10 May 2022

Re: Bayside Council Submission: Raymond Avenue Multi Level Warehouse Matraville (SSD-31552370)

Thank you for the opportunity to comment on State Significant Development (SSD) application for a warehouse and distribution facility at 42-52 Raymond Avenue and 44A McCauley Street, Matraville in Randwick Local Government Area (LGA).

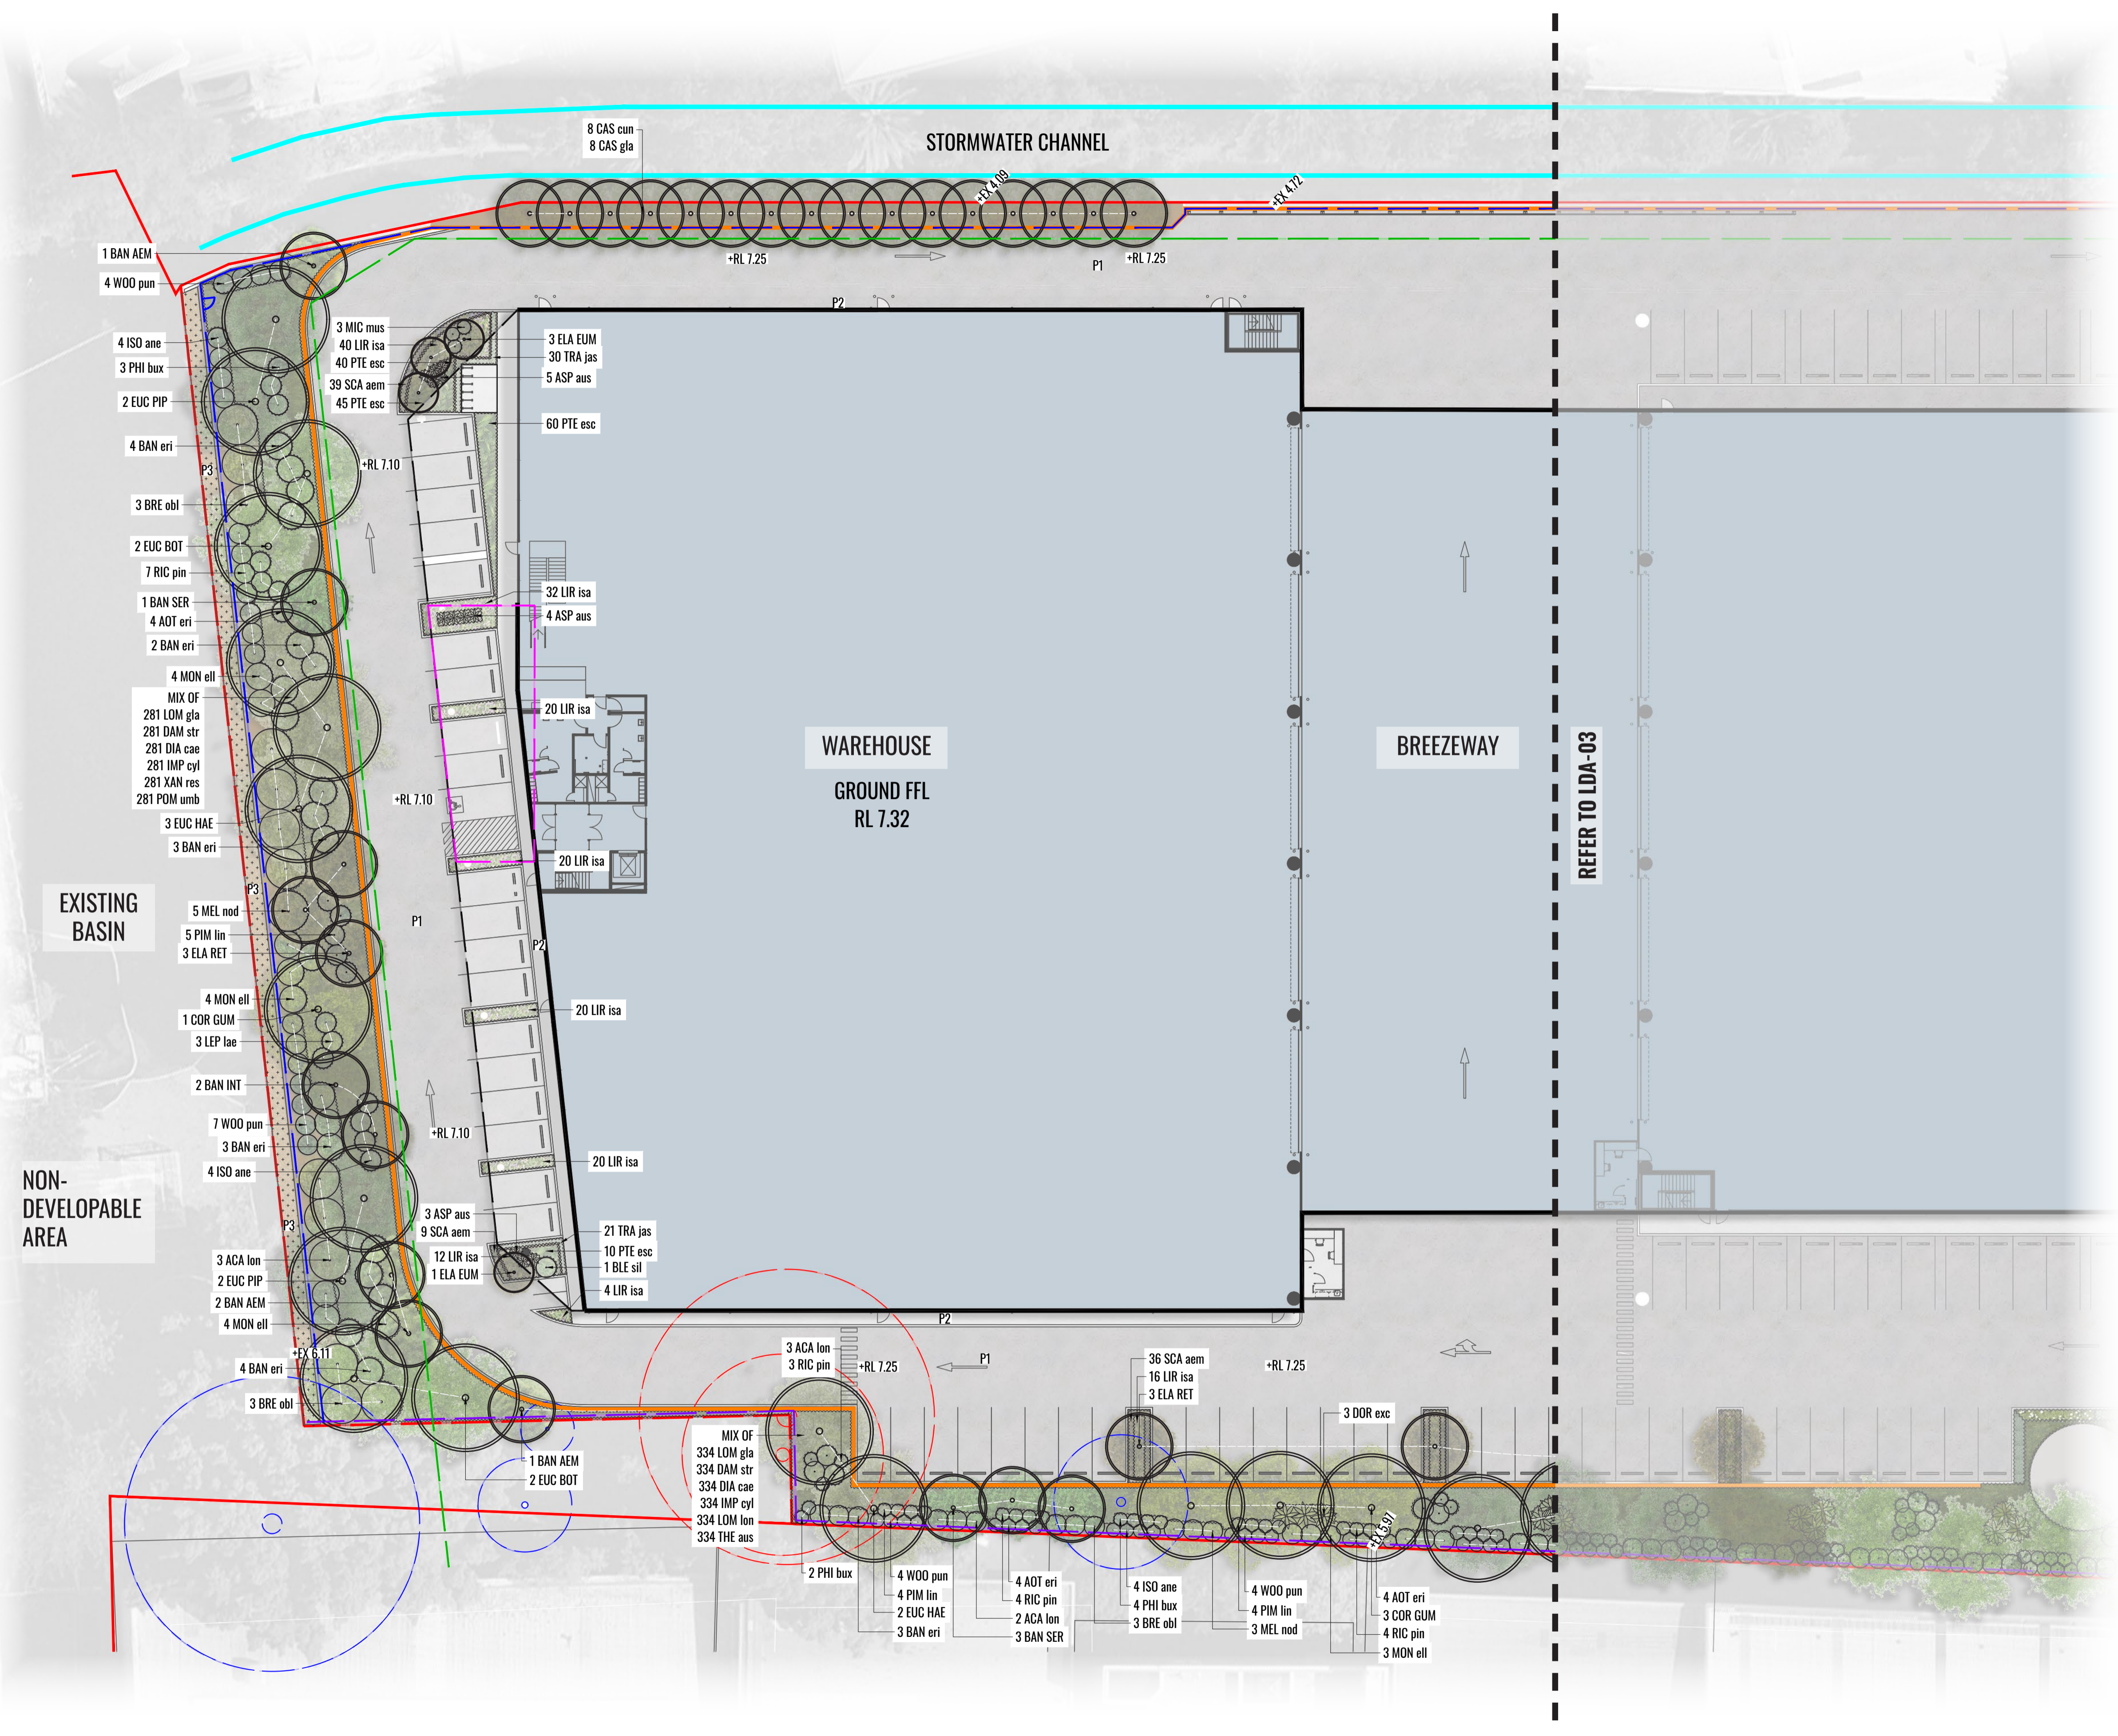
The proposed landscape plan does not include any landscaping along this boundary. Council recommends the inclusion of larger landscaped areas and setbacks along the north western boundary of the site to provide visual breaks and screening to buildings located within the development. In addition, non-reflective materials and colours will need to be included in the finishes for the development to reduce the potential for reflectivity and glare towards neighbouring industrial properties in Bayside as well as reducing visual impacts.
